From: Darren Schofield [REDACTED]
Sent: 27 February 2018 10:39
To: Michael Eastham
Subject: RE: Courtwick Littlehampton - variation of conditions 4 & 24 - Ref LU/408/17/PL

DMA Strider Max 4 Mobility Scooter	1.440m
Overall Length	0.650m
Overall Width	1.225m
Overall Body Height	0.165m
Min Body Ground Clearance	0.650m
Track Width	2.00s
Lock to lock time	1.650m
Wall to Wall Turning Radius

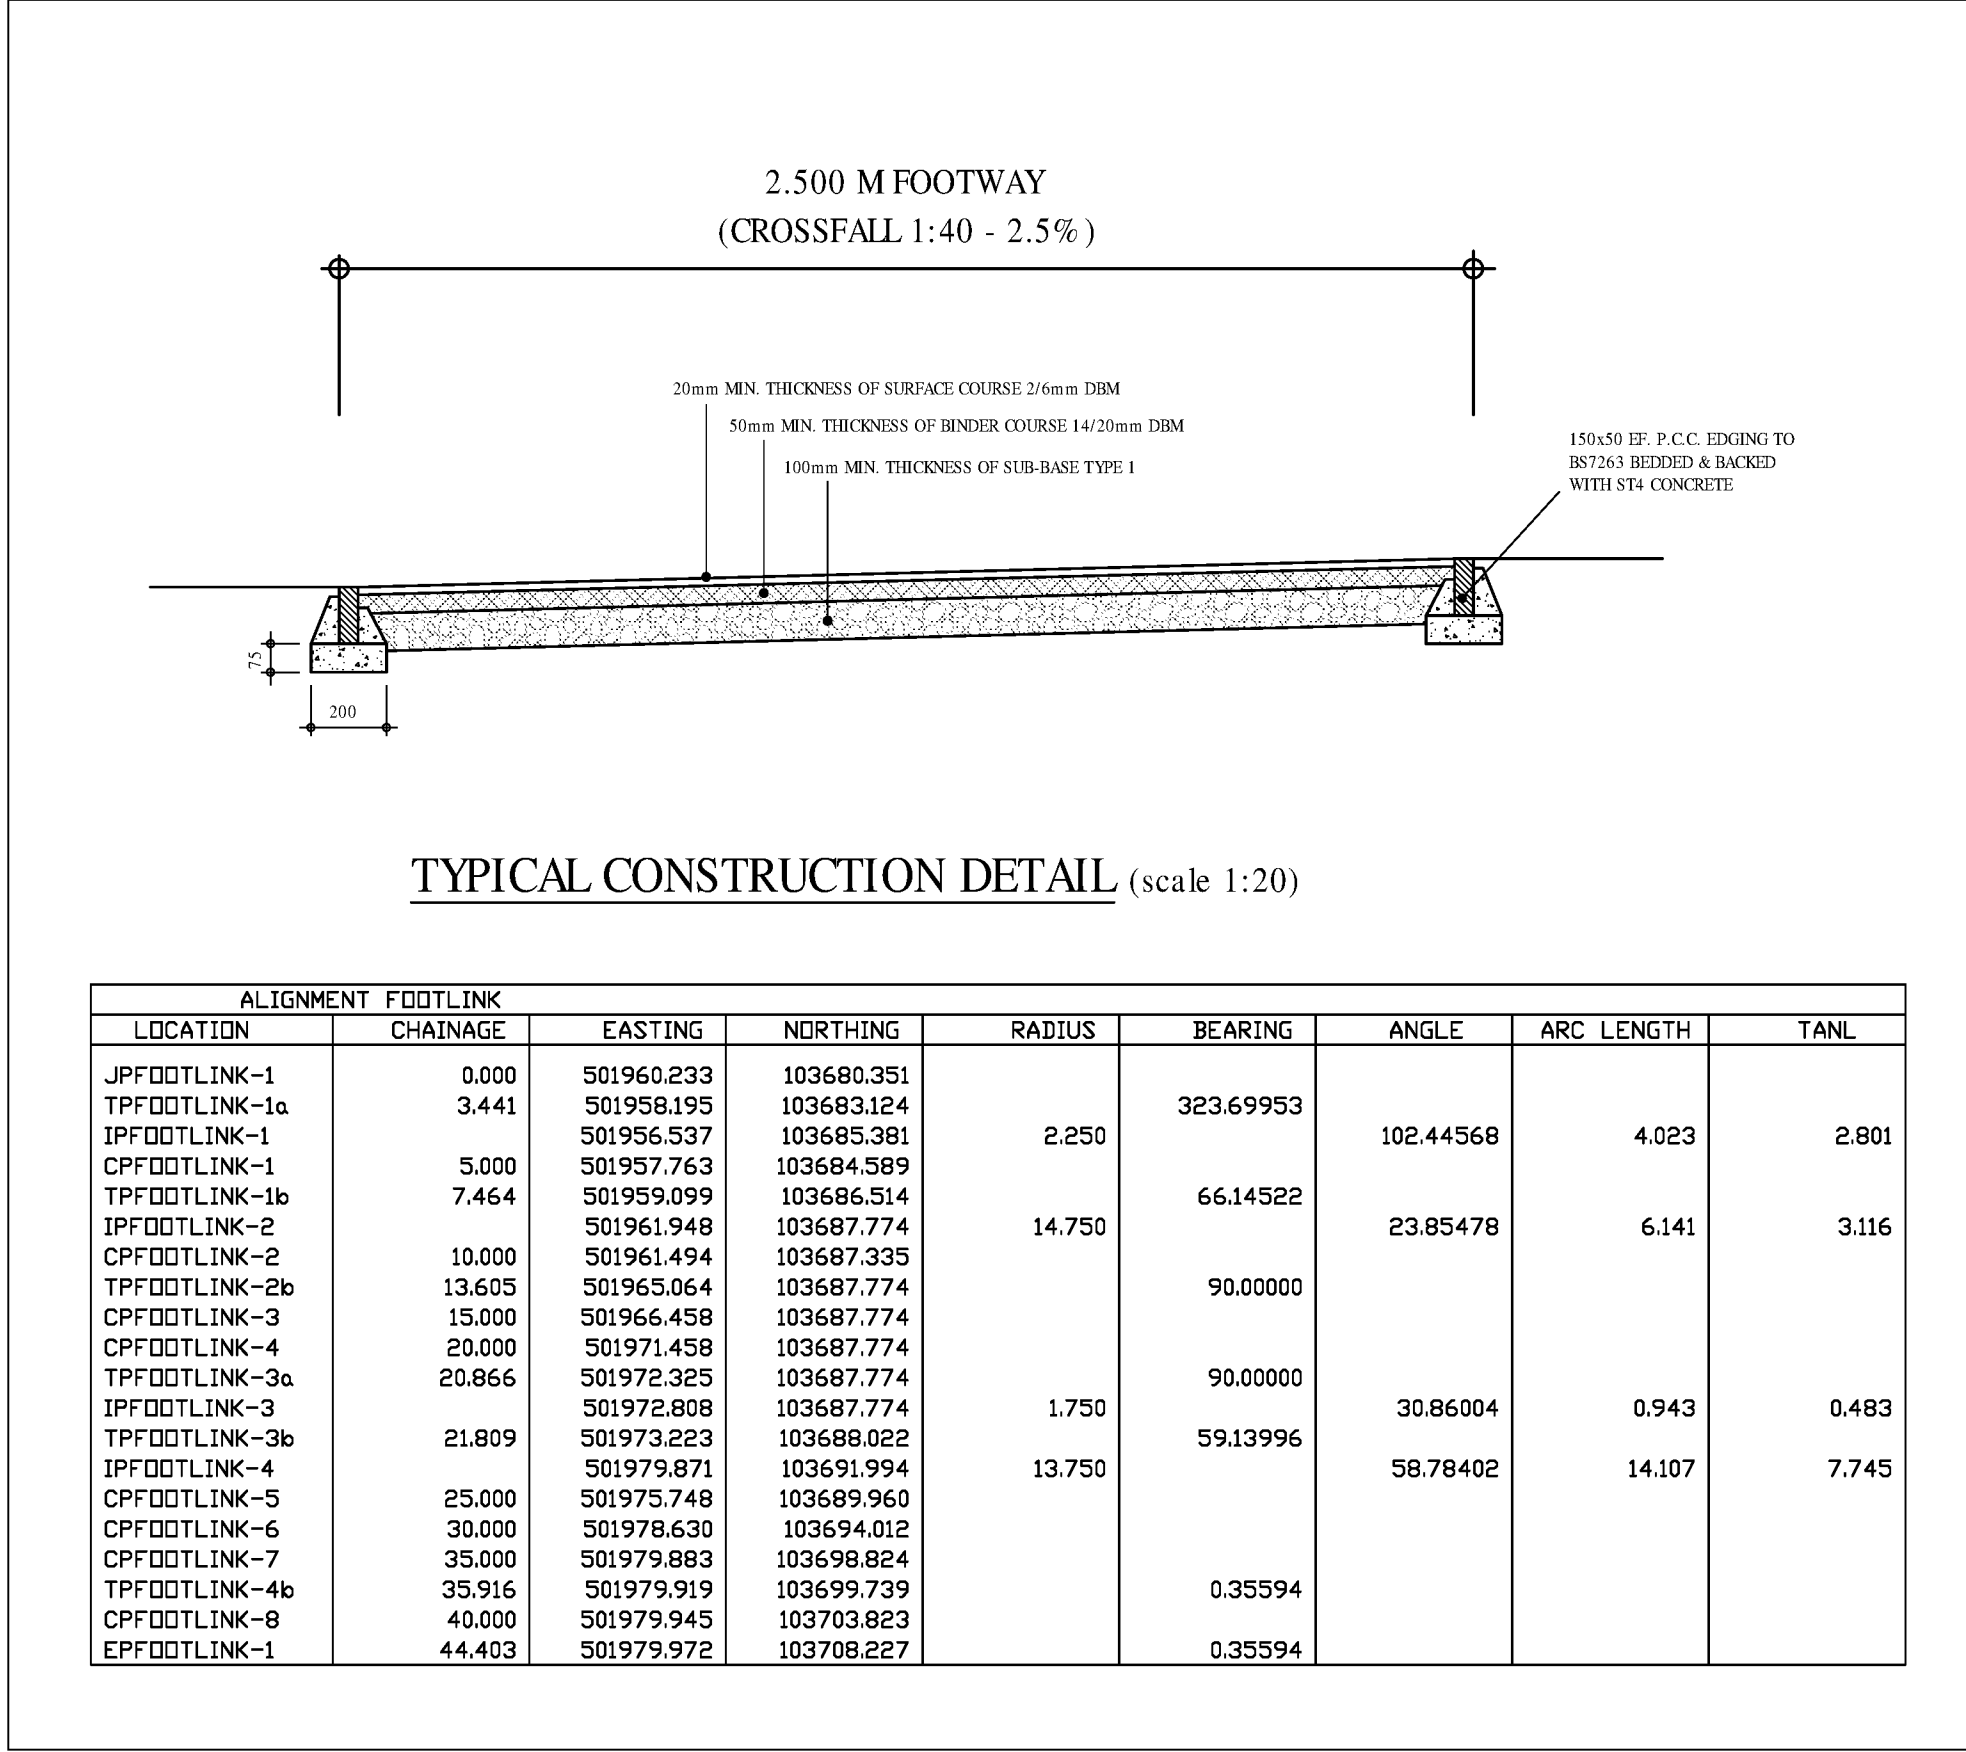
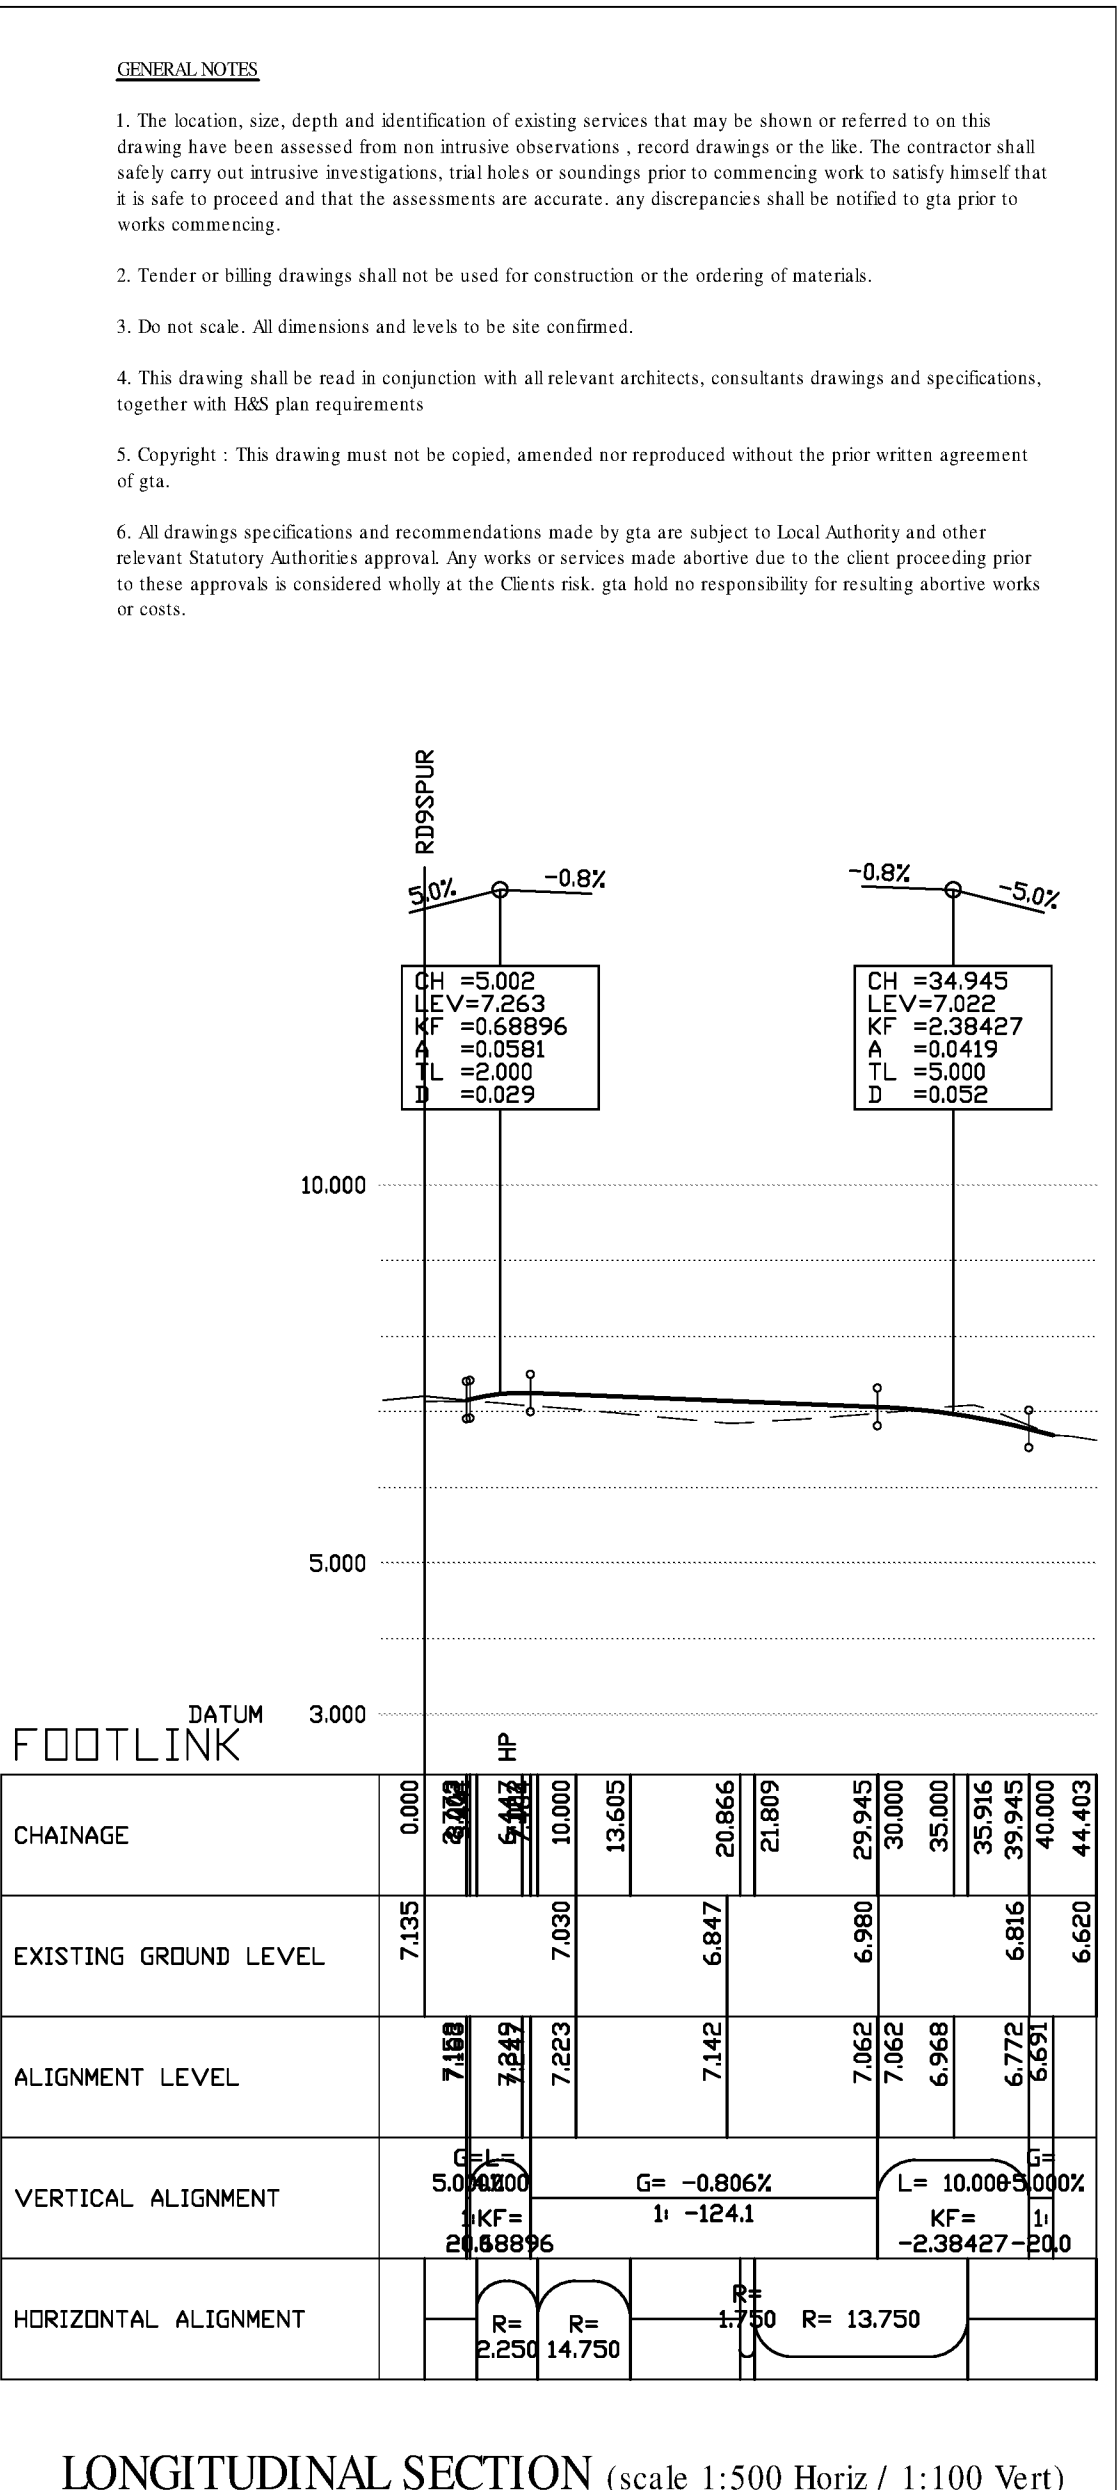
One further point that I meant to include on the email below. Please would you also ask Bellway to demonstrate on a plan that those with pushchairs and mobility scooters can negotiate the barriers. Also with the revised sight line, the barriers will need setting-back to accommodate the greater 'x' distance.

- 1. Pedestrian visibility** – This needs to be shown from a 2.0m 'x' distance - *not* 1.0m as shown. This was raised previously and discussed with Darren when I met him on site. The plan does, therefore, need to be amended.
- 2. Advance warning signage of pedestrians** – The Stage 1-2 Road Safety Audit - February 2018, para. 2.1.1 - recommends that a sign be provided on the approach to the pedestrian access warning drivers of the presence of pedestrians. WSCC recommends that a further sign be placed on the opposite approach for drivers travelling eastbound. Again, plan should be amended to show this.

I attach an updated plan picking up on Tim's comments, along with a barrier chicane standard detail.
